**RE: ENGINEERING RESPONSE TO SUBMISSIONS RELATING TO SSD 9227 - PROPOSED AMITY COLLEGE SCHOOL CAMPUS AT NO.85 BYRON ROAD AND NO.63 INGLEBURN ROAD, LOTS 1 & 2 DP 525996, LEPPINGTON, NSW**

Martens and Associates (MA) have undertaken a review of Camden Council's submission to the SSDA submission in a letter dated 8<sup>th</sup> October 2019 (attached). This response focuses on Councils' comments relating to civil engineering matters.

Council comments in Table 1 below relate to the MA engineering plan set submitted for the SSDA, drawing reference P1806493PS01-R09 revision G dated 24/07/2019.

CONCEPT FUTURE BYRON ROAD (21-MRC01) LONGITUDINAL & TYPICAL SECTION

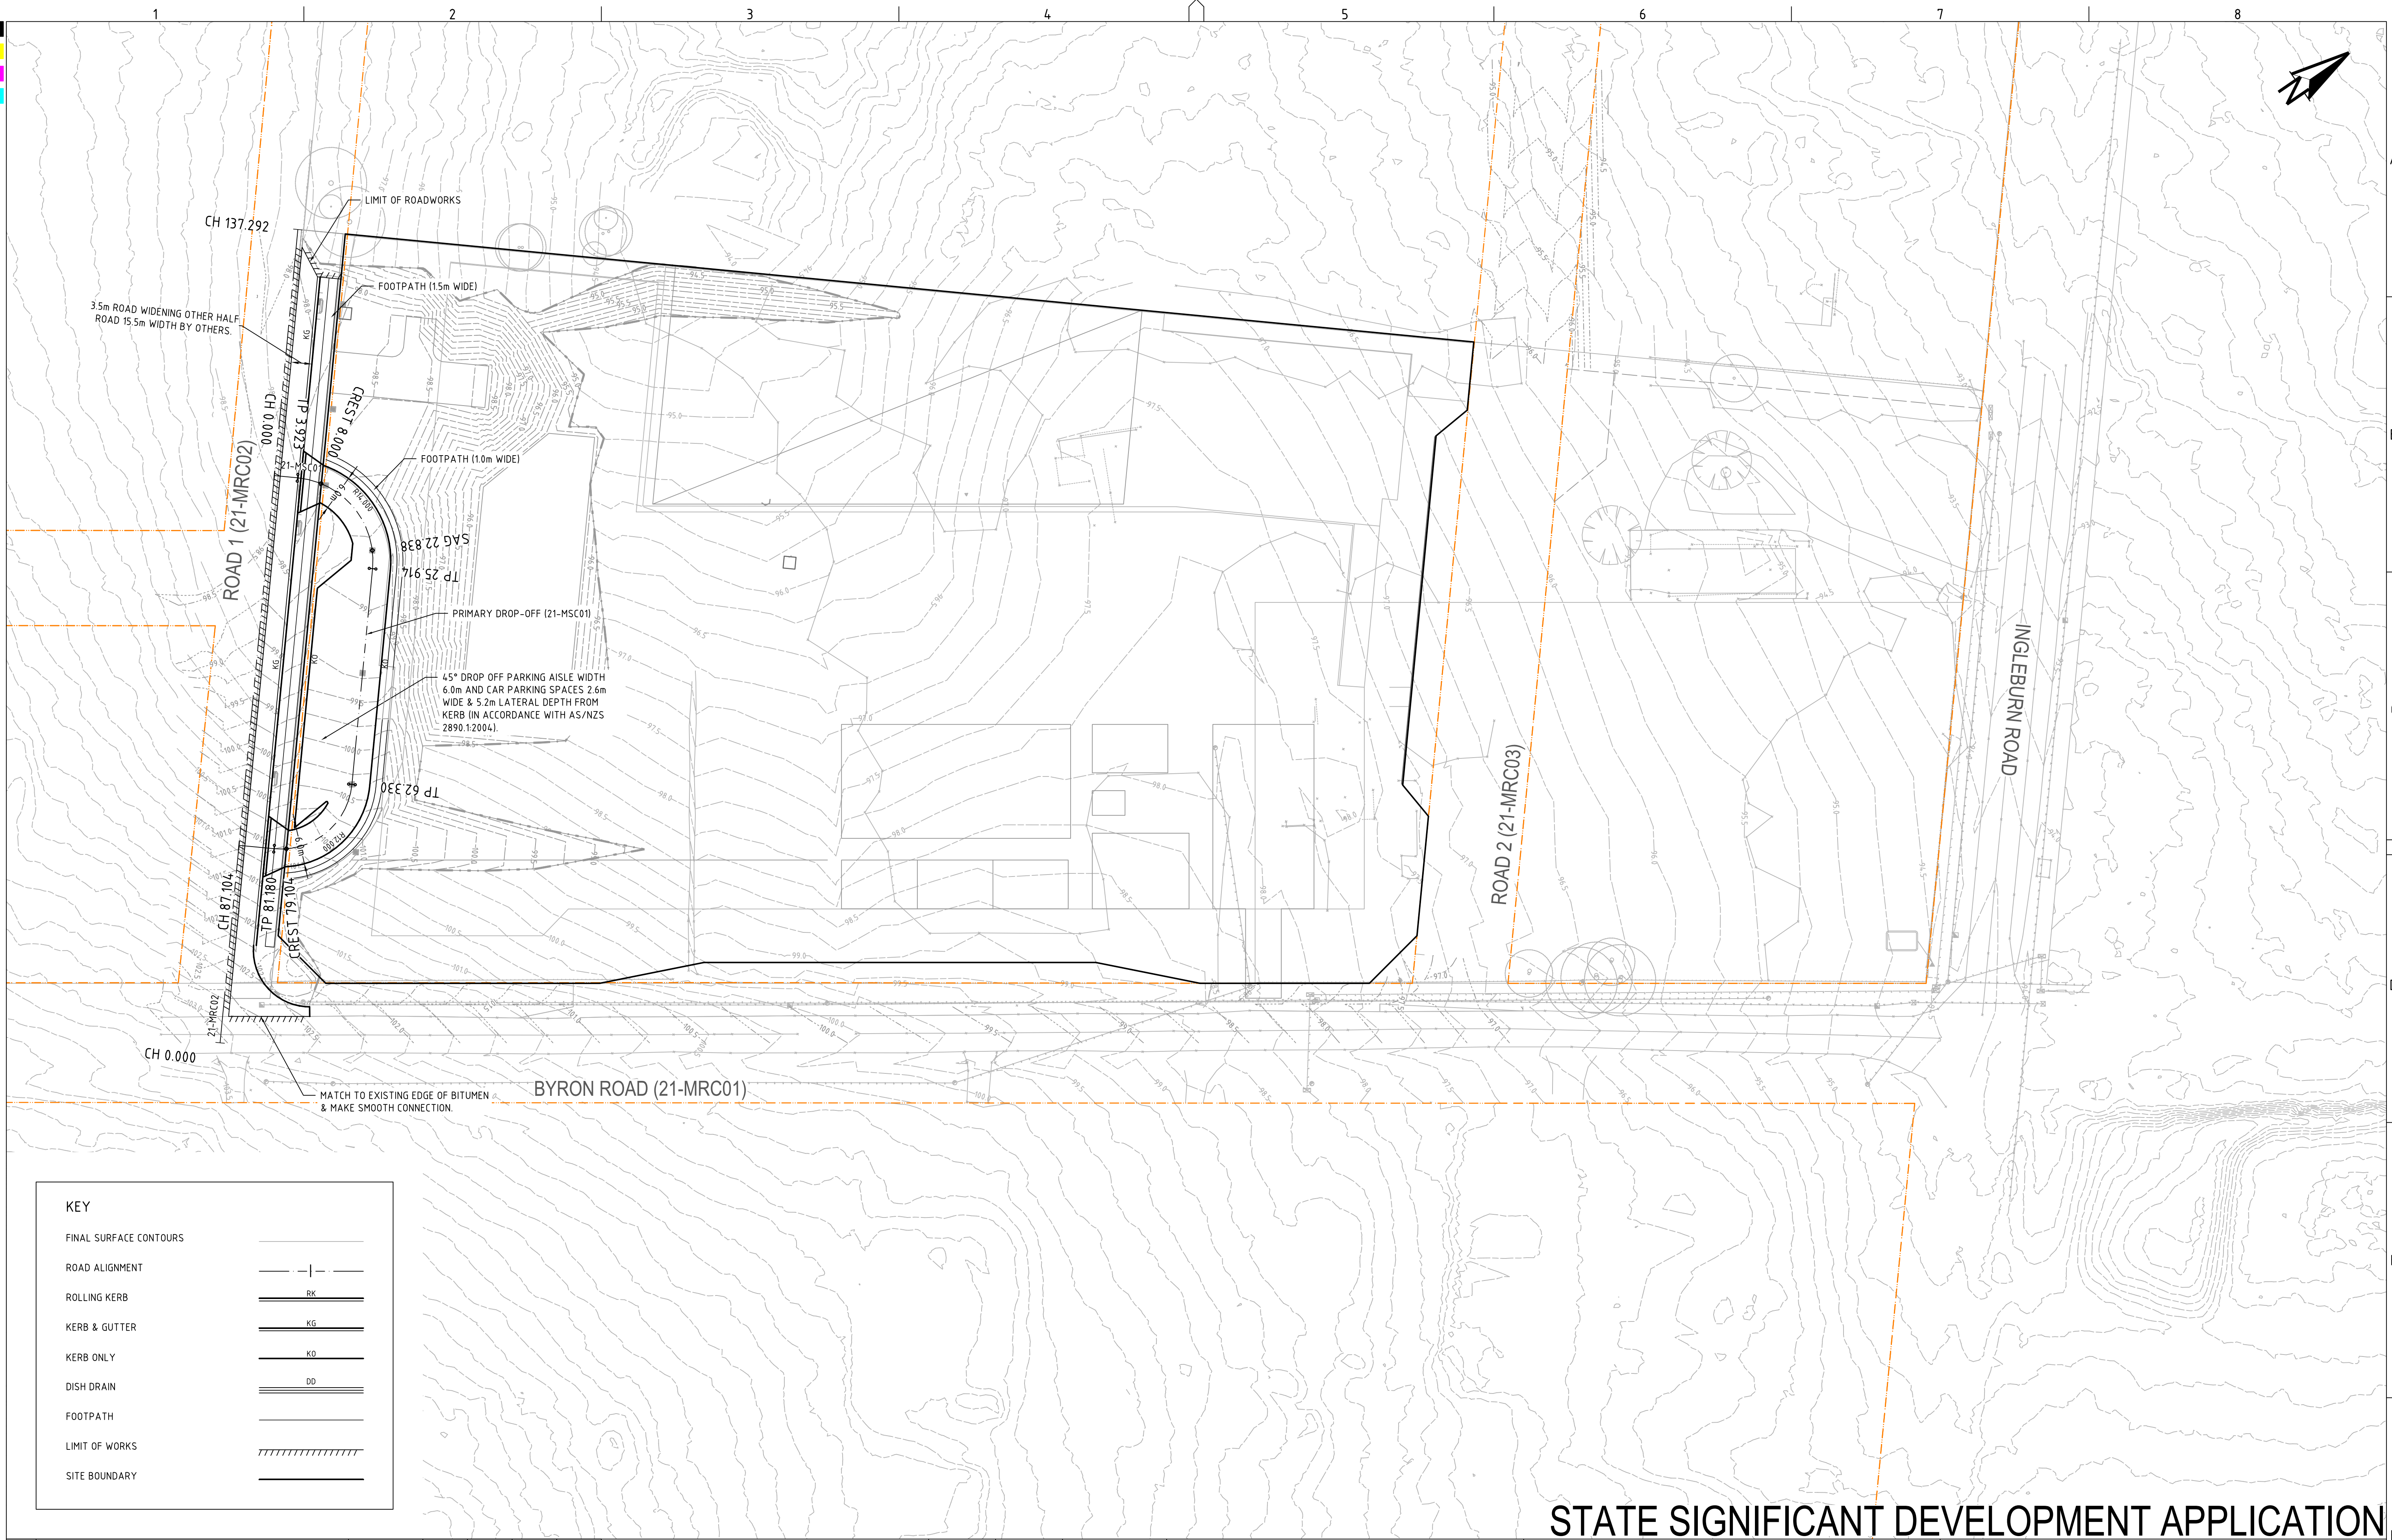
6	The proponent must provide cross sections at 15m intervals along Byron Road at the property. The cross sections must show the temporary interim and ultimate Byron Road levels in relation to the development. Reference should be made to Section 2.2.3 of Council's Engineering Design Specifications.	Cross sections to be provided at S138 stage for approval. No staged road works are proposed.
7	The proponent must indicate locations of V5 lighting along Byron Road's frontage.	By others.
8	The submitted engineering plans detail that underground electrical, water and telephone services are located at the Byron Road frontage. The proponent must indicate the required relocation of these services as	A note can be added to the plans relating to services relocation. This can be conditioned as part of the consent.
